From: wilpshire parish council <wilpshireparishcouncil@gmail.com>
Sent: 11 September 2018 07:45
To: planning; wilpshire parish council
Subject: 3/2018/0647 Braemar House off Somerset Avenue Wilpshire - Comments

3/2018/0647 Braemar House off Somerset Avenue Wilpshire

drawing title:
PROPOSED FLOOR PLANS

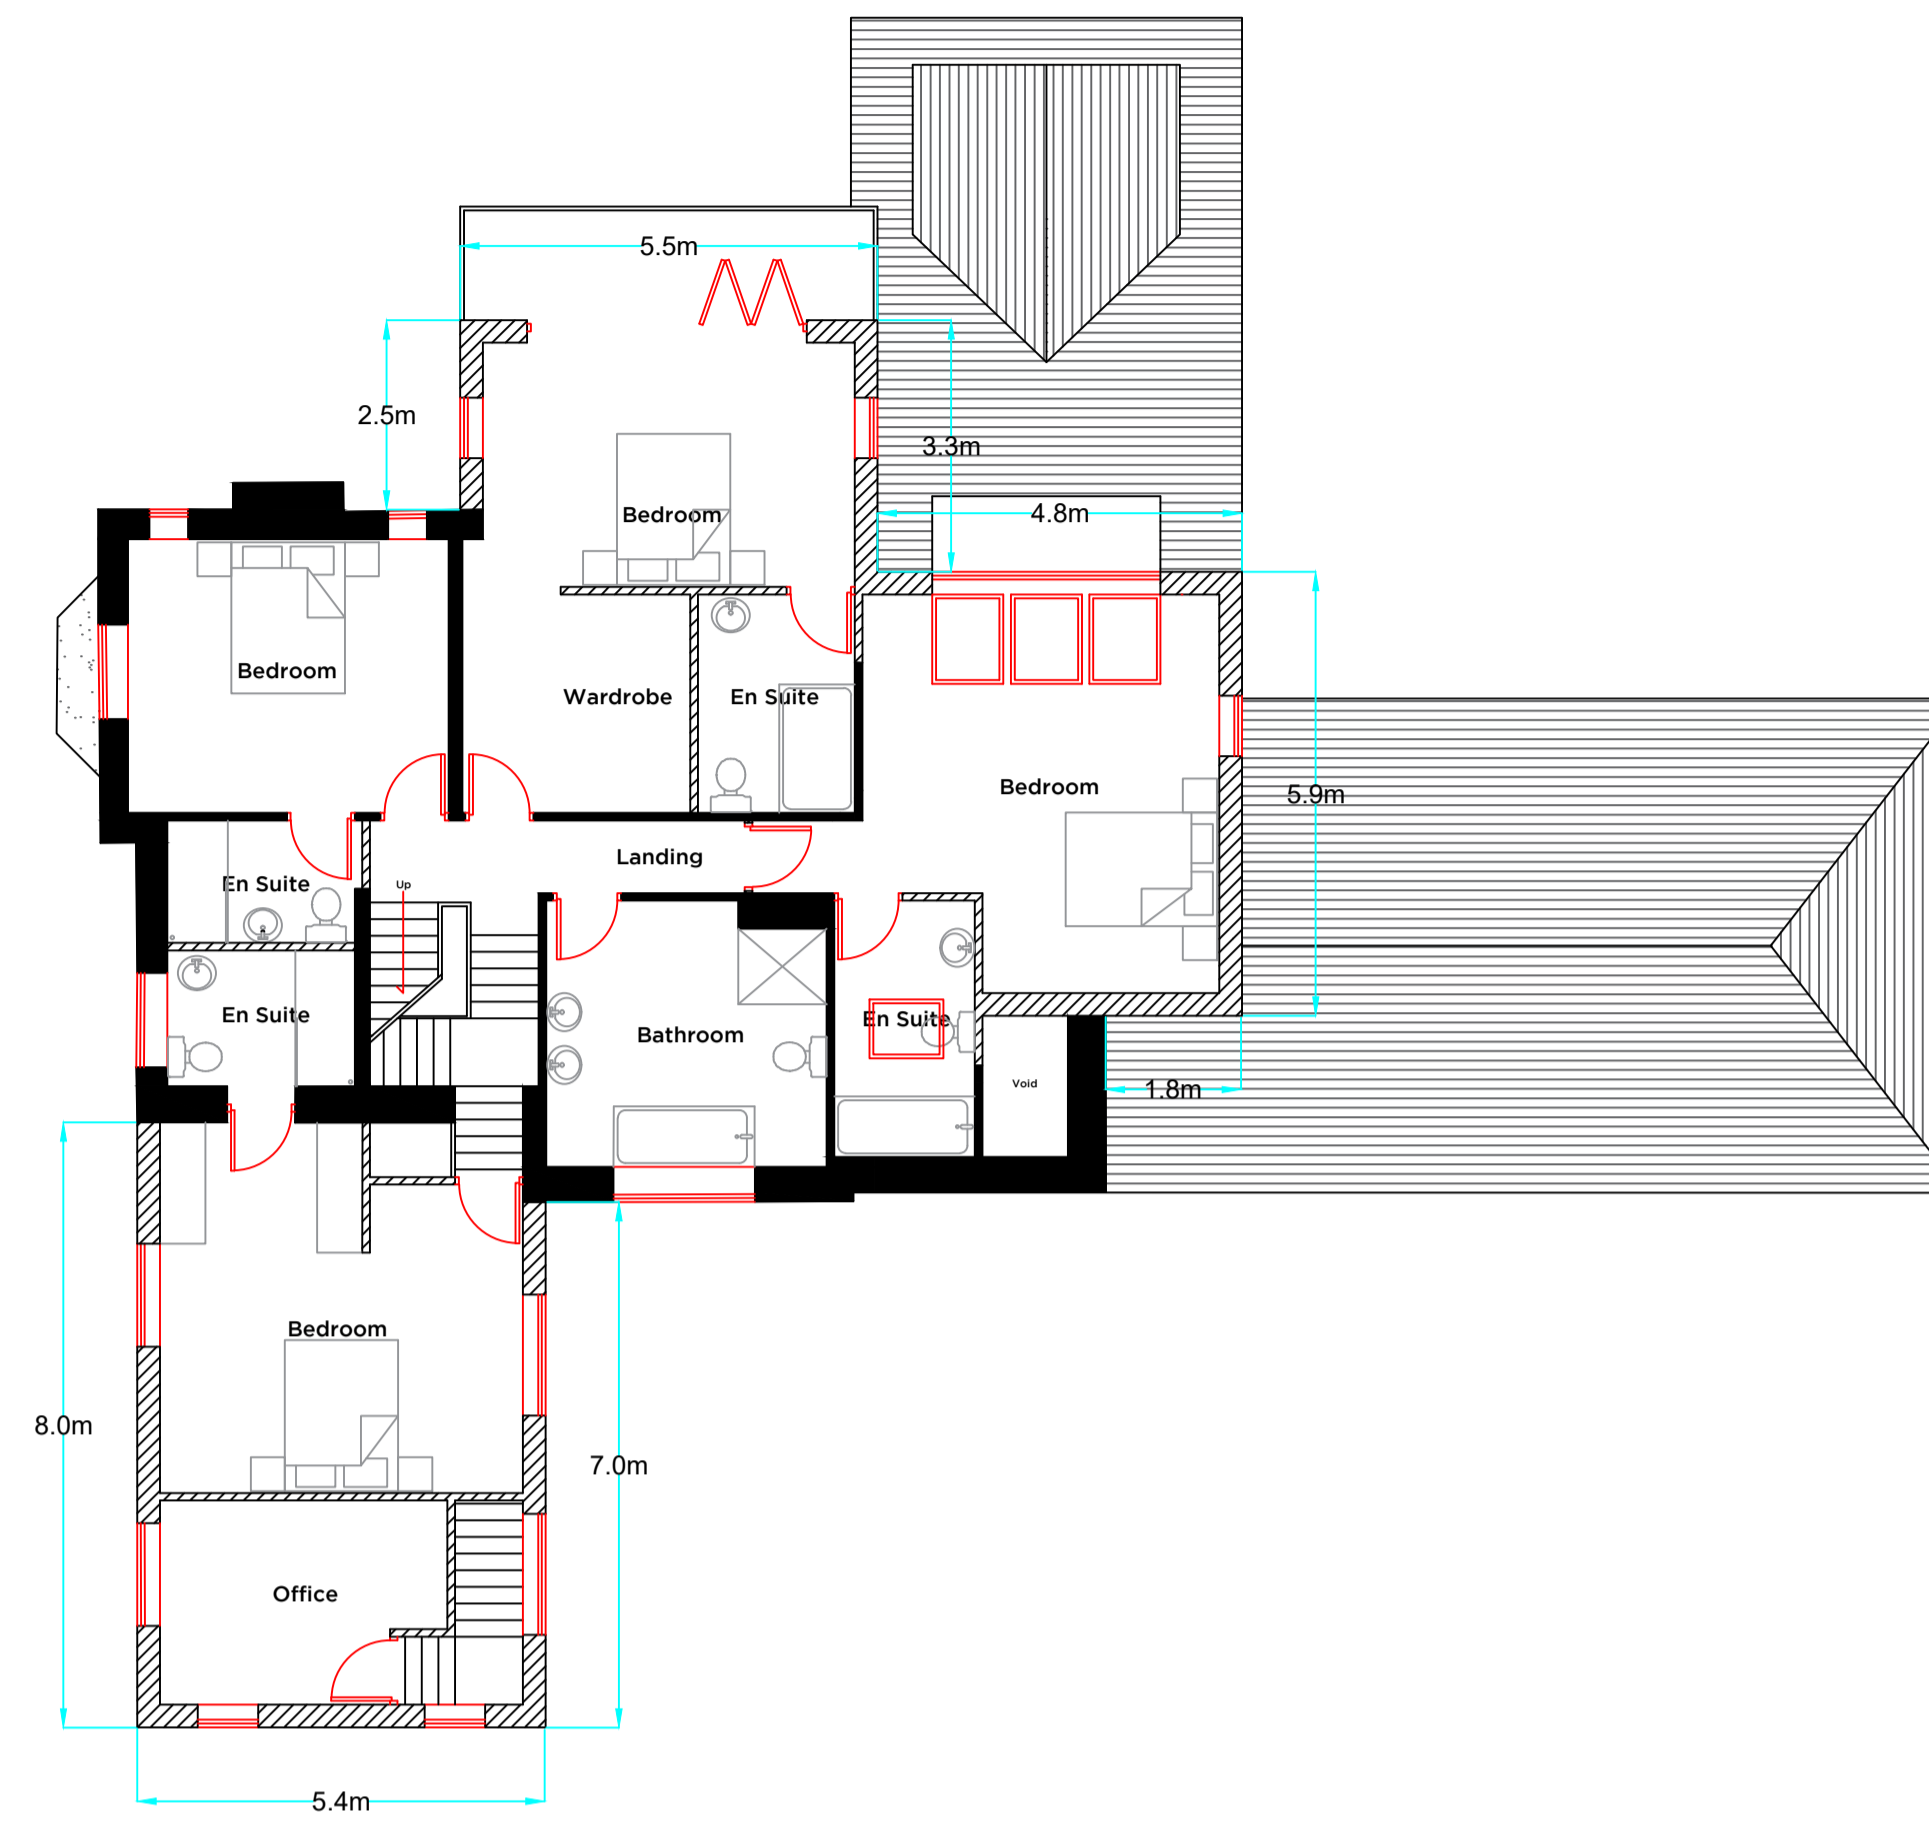
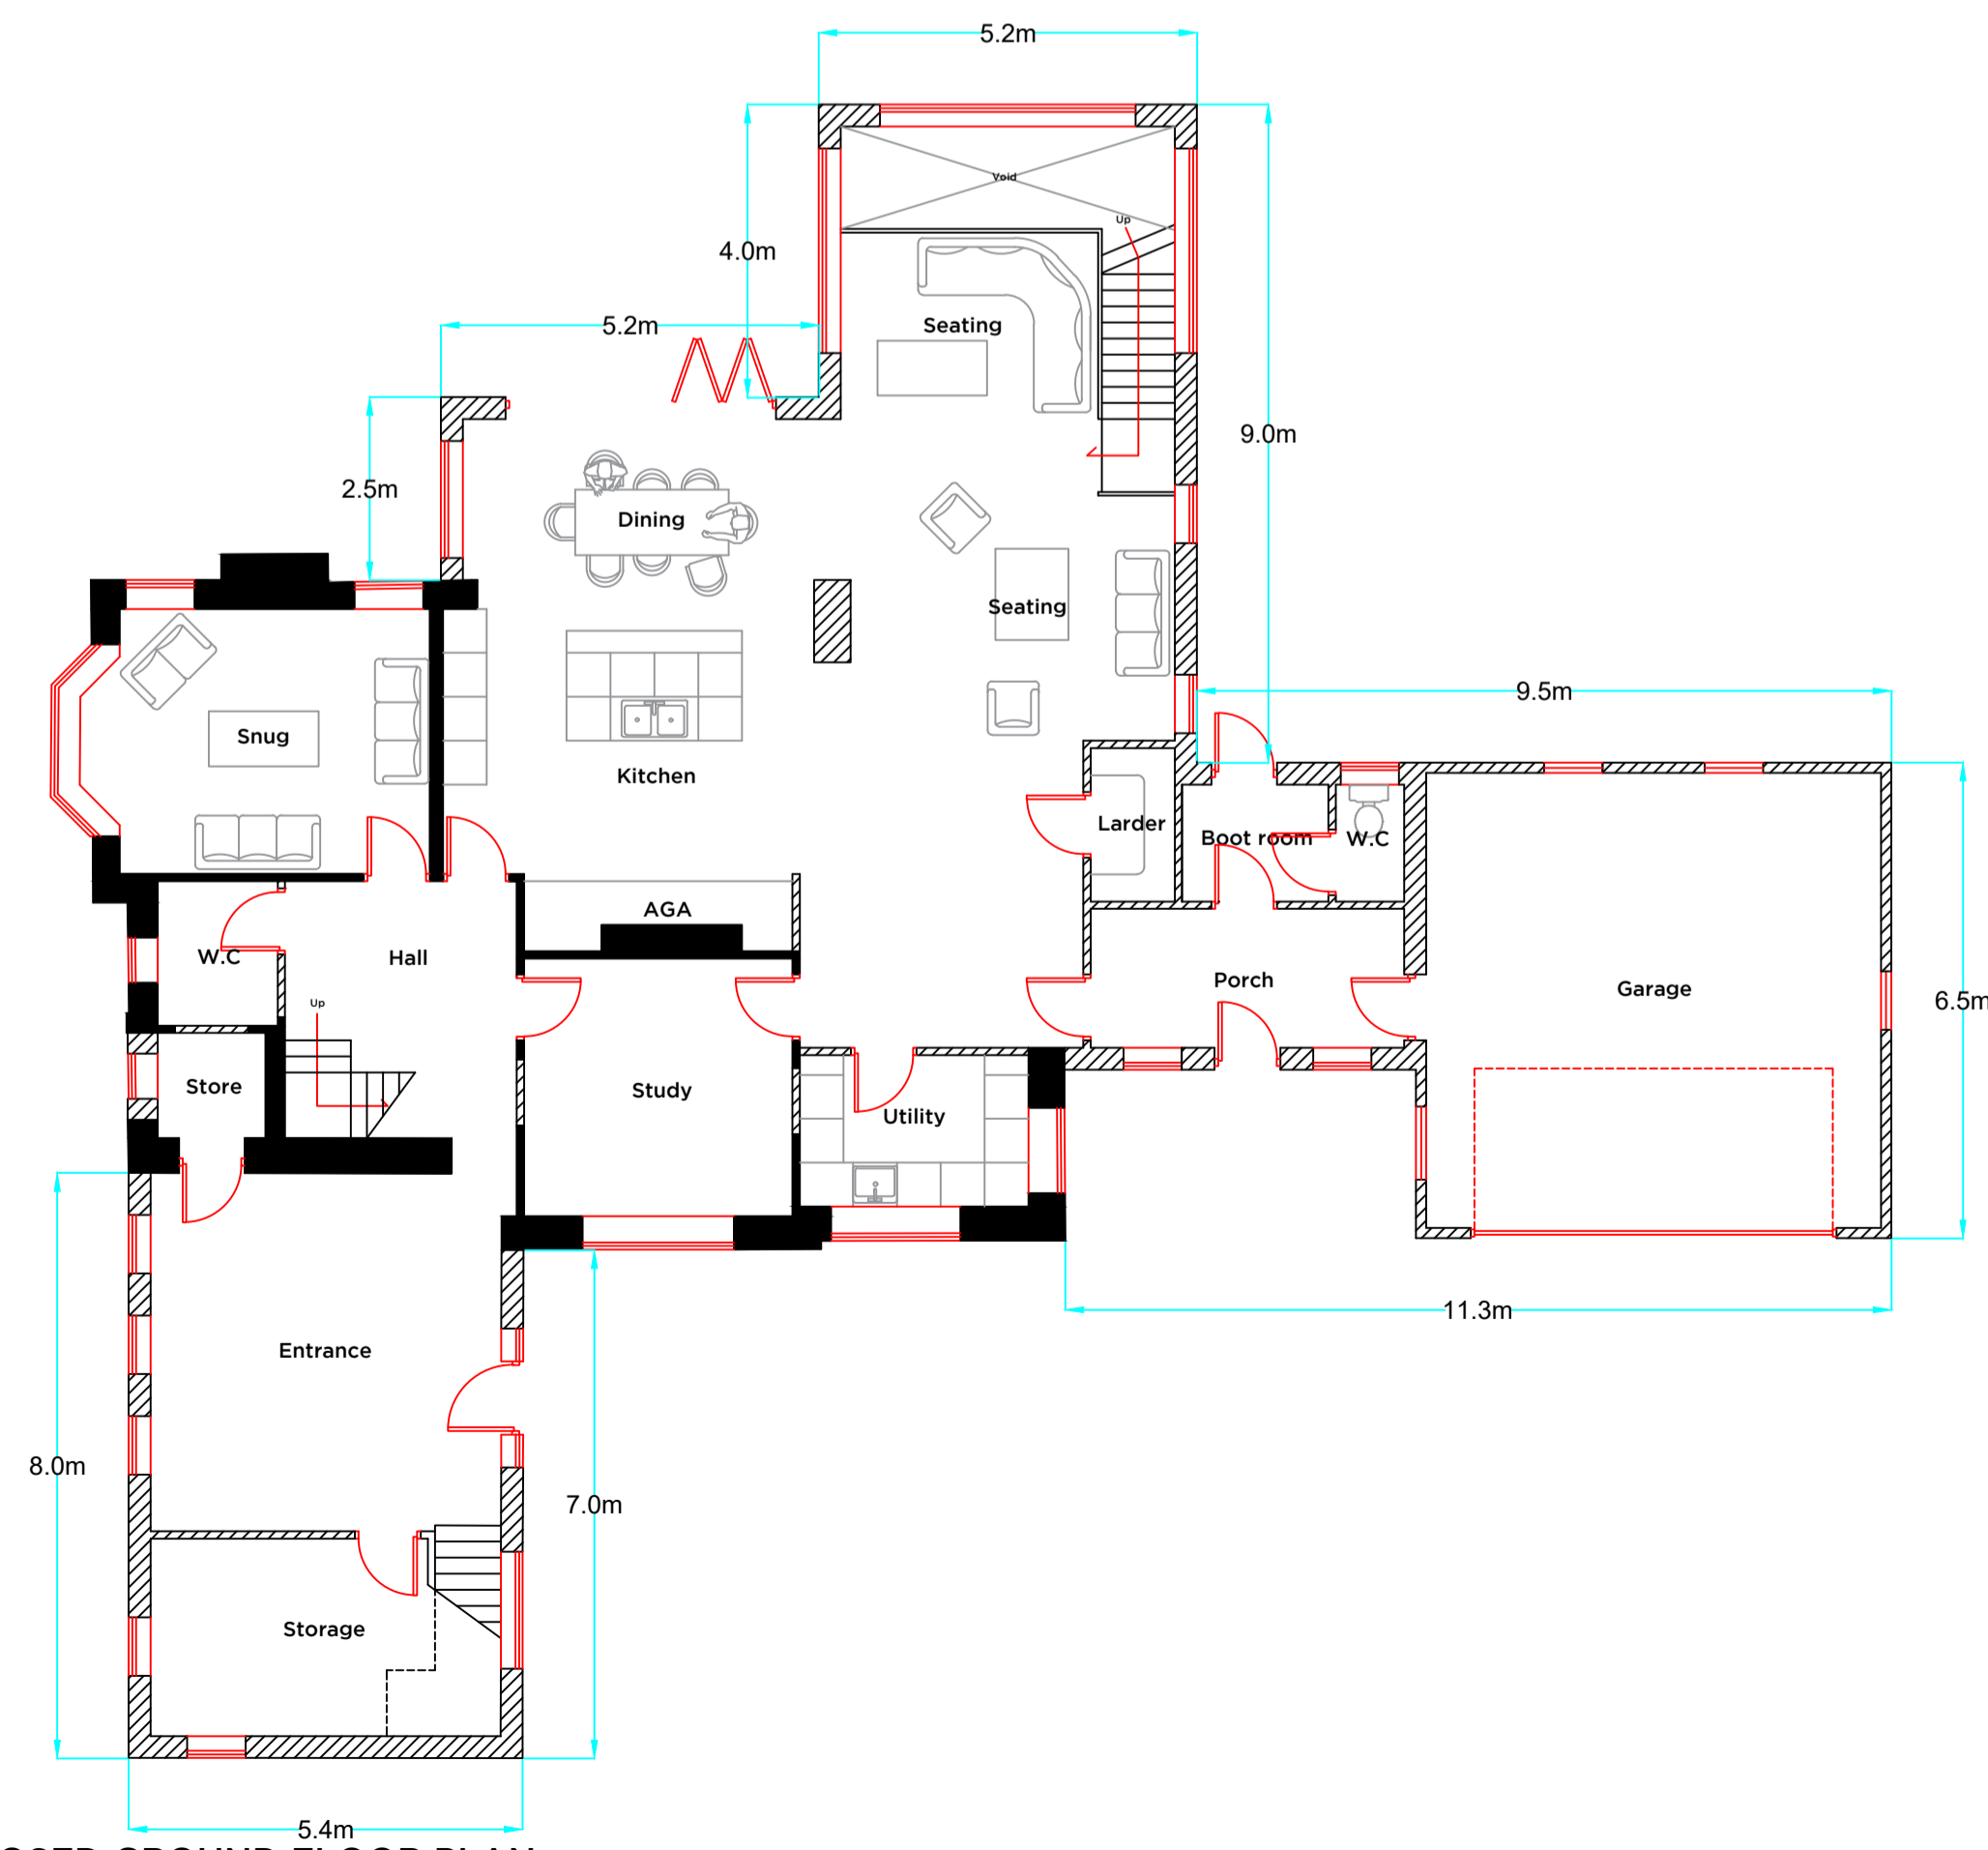
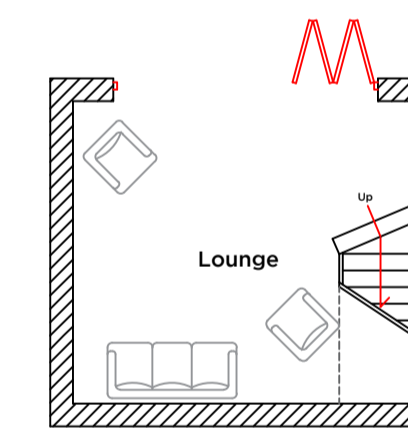
Wilpshire Parish Council feel that the proposal would be overbearing as two significantly enlarged elevations will be very dominant. On one elevation it would have the appearance of a four storey building. There would be a large increase in the buildings footprint.
